Application No: BR/263/20/HH
Site Address: 44 Corbishley Road Bognor Regis PO21 9HS
Description of works: Detached single storey outbuilding

Thank you for your internet representation made on 1st December 2020 which has been recorded as an objection with the comments as follows:

PROPOSED DETACHED OUTBUILDING AT 44, CORBISHLEY ROAD, BOGNOR REGIS
FOR MR. A. PAULVR,

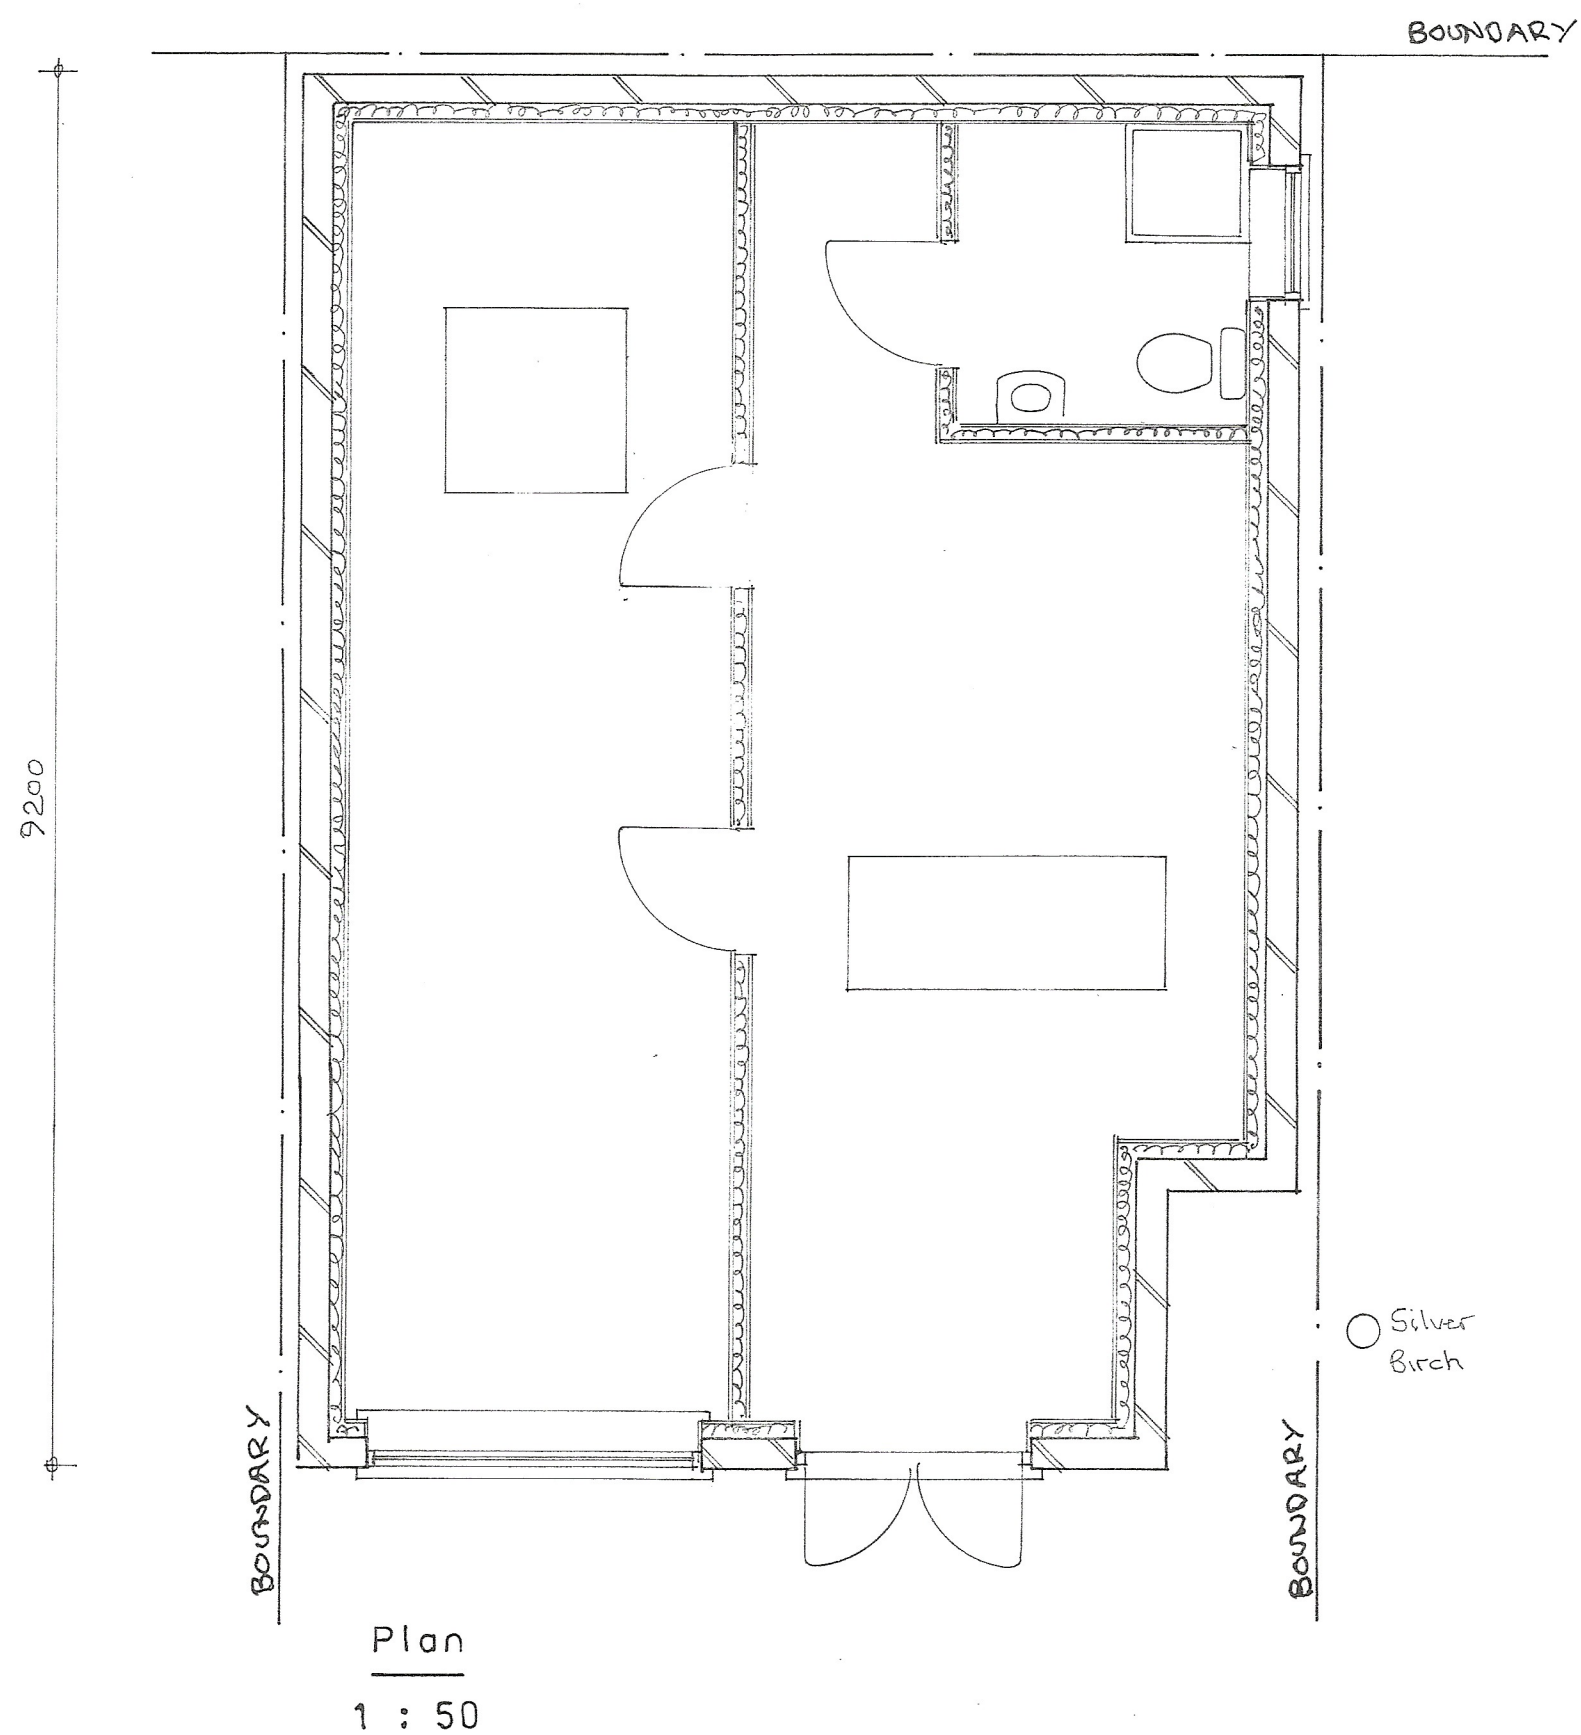
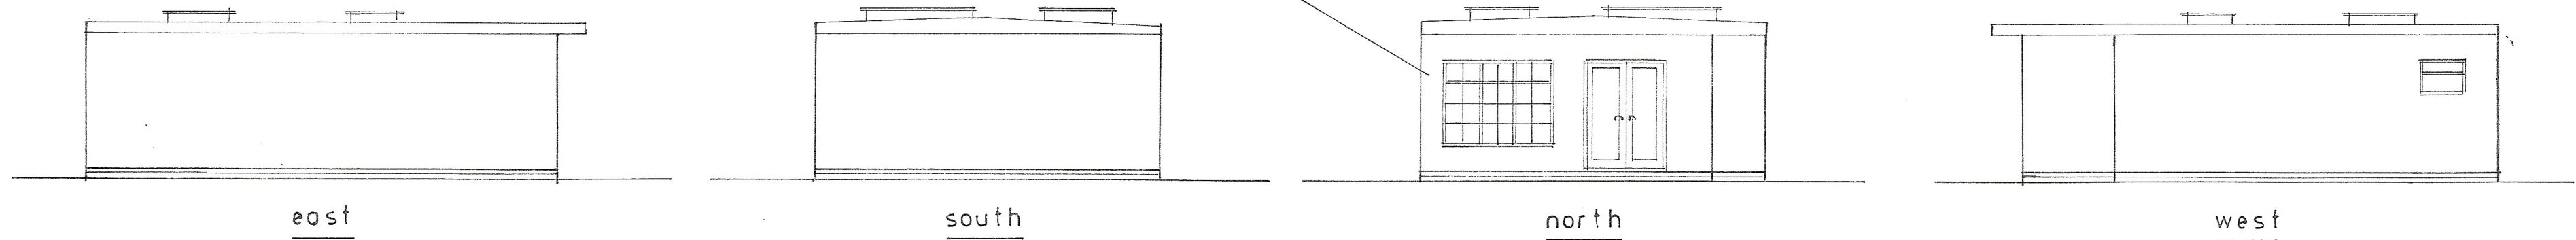
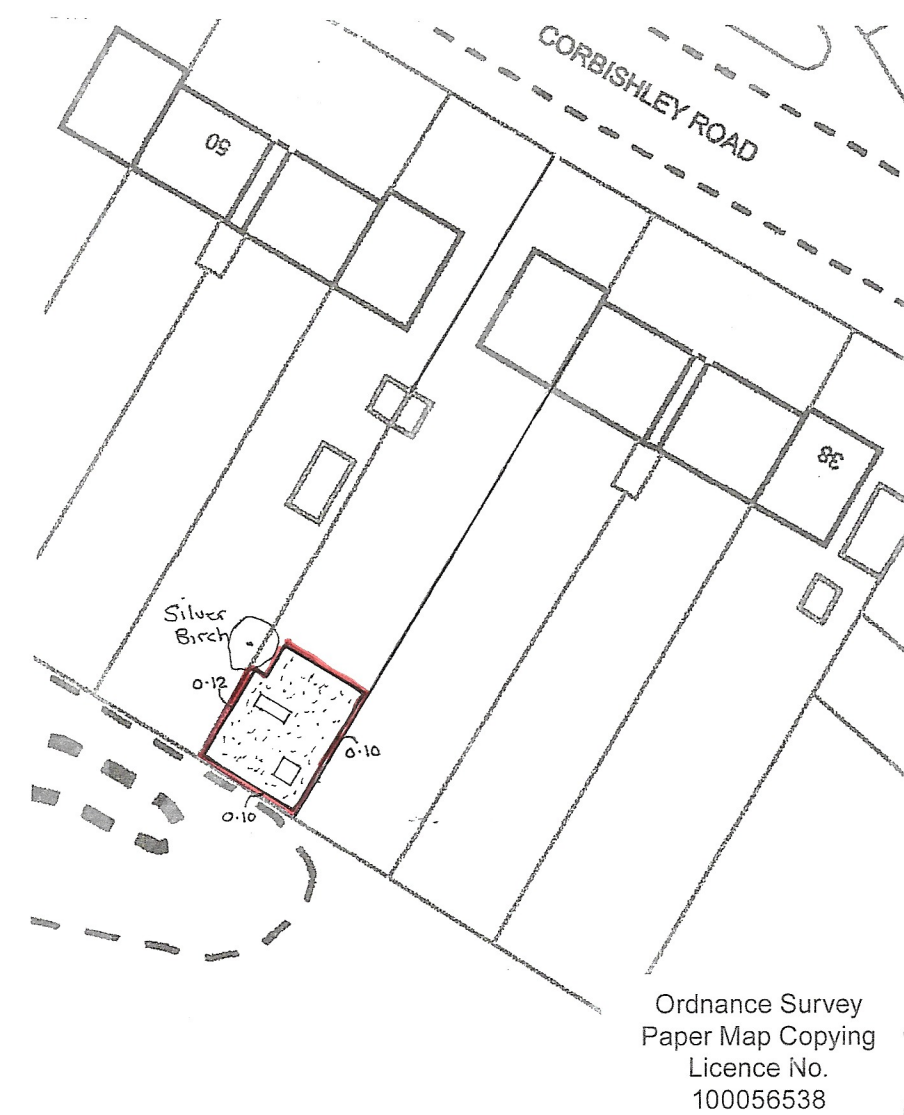
Outbuilding is too large/high.

1. Brick extension at rear of main house not shown.
2. Metal shed next to existing brick outhouse not shown.
3. Window at East elevation, overlooking end of our garden, not shown; obscured except at top by fence affixed to new outbuilding.
4. Skylight on east side does not exist.
5. Toilet, basin & possible shower area shown - is this allowable?

No guttering affixed to new outbuilding; we are concerned that overflow will spill onto our property during heavy rain.
